From: Hornby, Mark [mailto:Mark.Hornby@lancashire.gov.uk]
Sent: 21 July 2011 16:00
To: Colin Sharpe
Cc: ENV EPP Customer Service Area East
Subject: Highway comments on Planning Application 03/2011/0460 Land at Whalley New Road, Billington

**PLANNING APPLICATION 03/2011/0460
 LAND AT WHALLEY NEW ROAD, BILLINGTON, CLITHEROE**

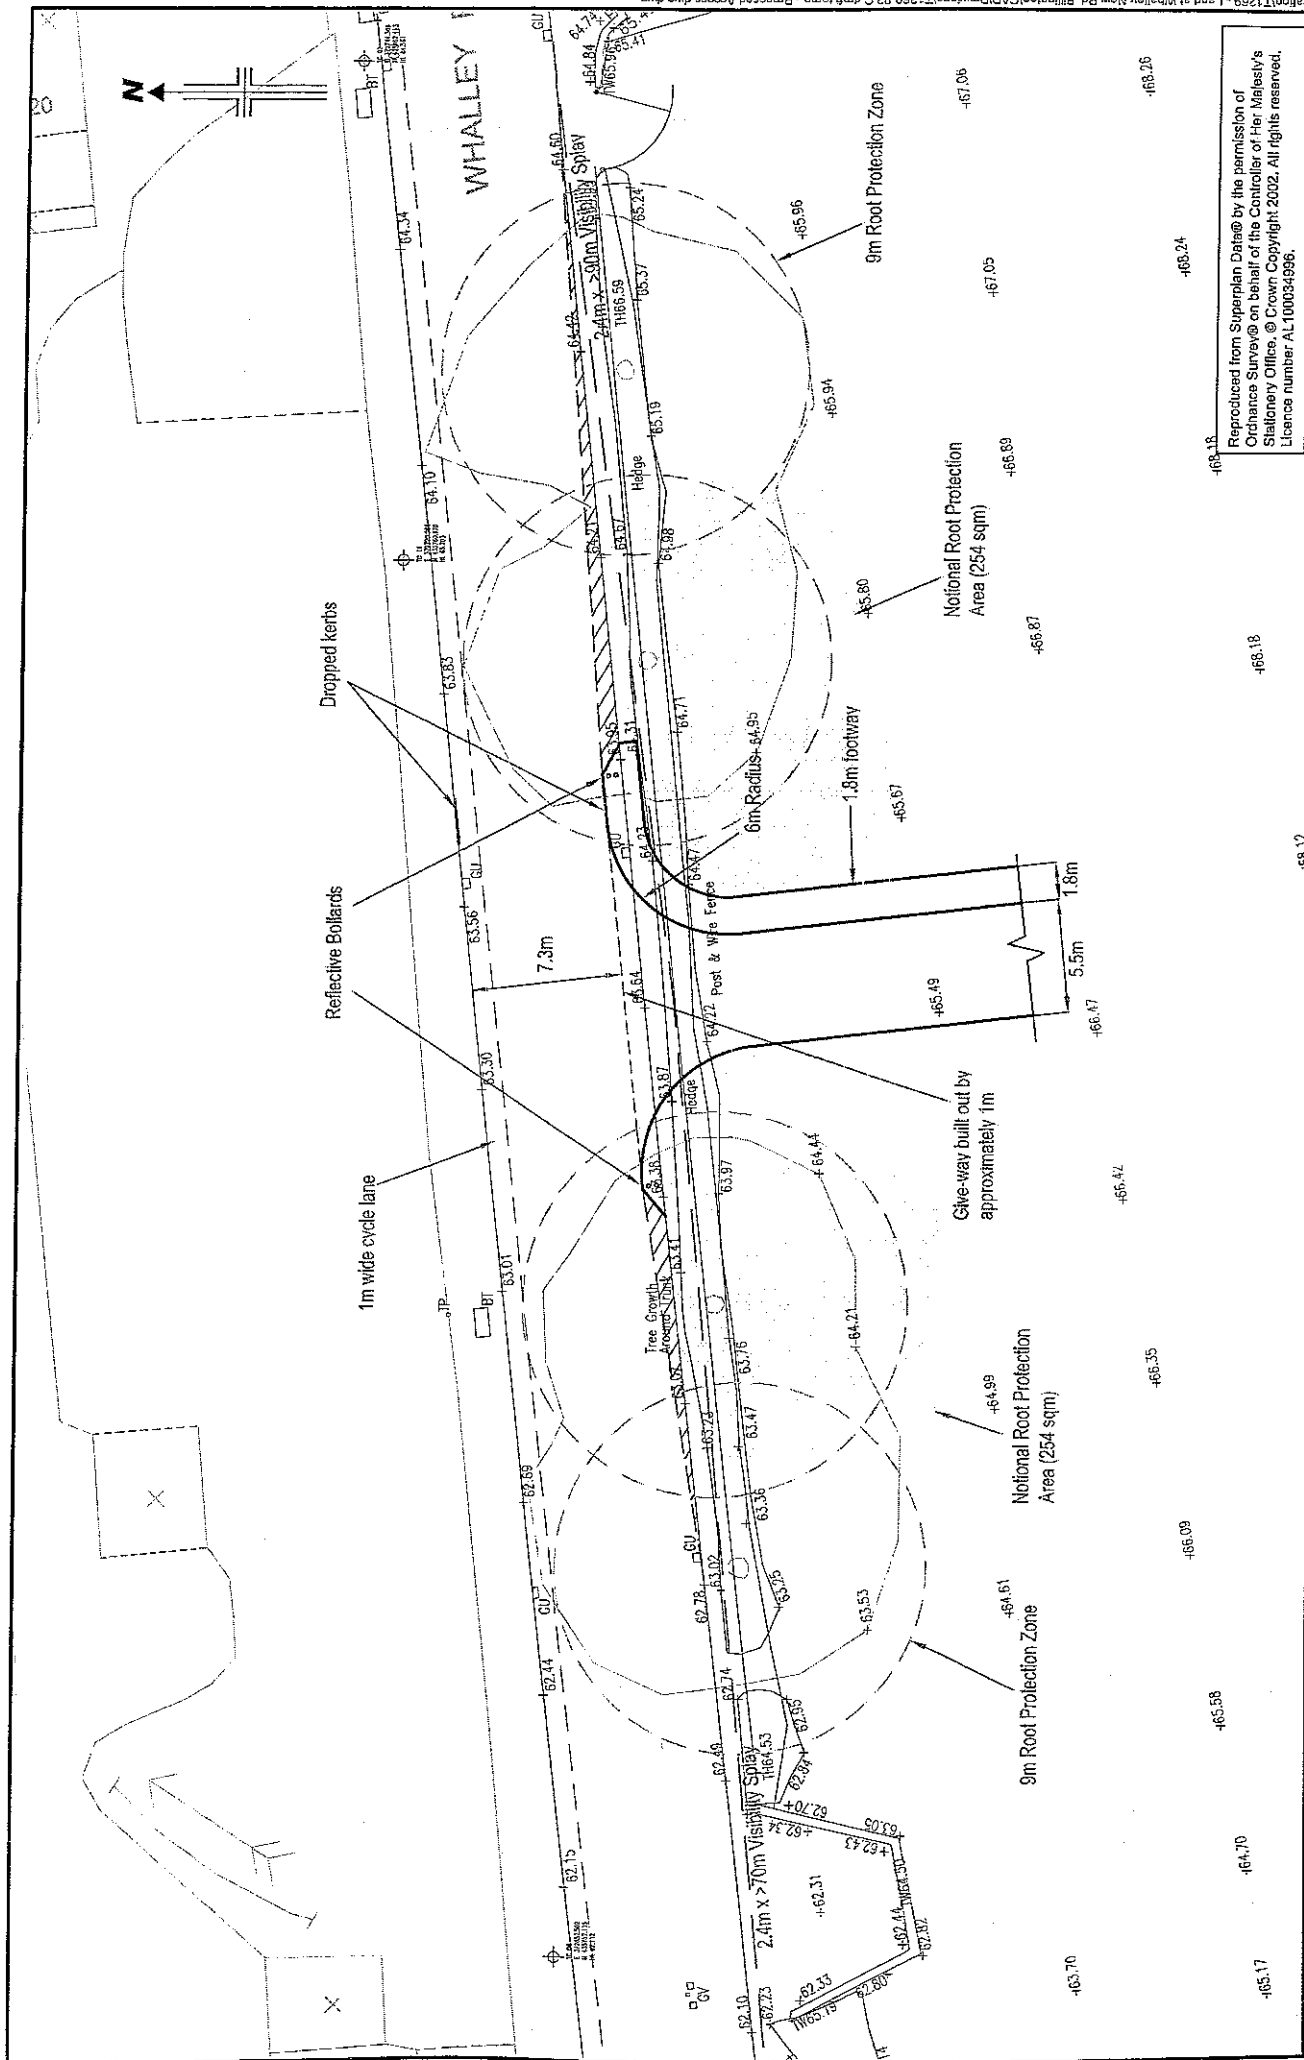
The proposed visibility splays at the access onto Whalley New Road of 2.4m x 70m to the west and 2.4m x 90m to the east are acceptable. The sightline to the west takes a very precise line across the trunk of the tree closest to the access. There is some scope to remove extraneous growth from around the trunk, with no detriment to the tree, and this could assist in achieving an acceptable sightline.

1. The remarking of the centre warning lines along Whalley New Road will be required as a result of the junction build-out extension at the entrance to the development.
2. The introduction of interactive signing on Whalley New Road to reinforce compliance with the 30mph Speed Limit.
3. There are no scheduled bus stops within a 250m radius of the site. It would be appropriate to consider improving this provision through the introduction of new stops on Whalley New Road. This could include items such as street furniture and the provision of suitable pedestrian links.

The construction of the build-out for the advanced Give Way at the site access and the other physical measures will require a Section 278 agreement, as will the proposed lengths of footway fronting the highway and the drop kerbs opposite.
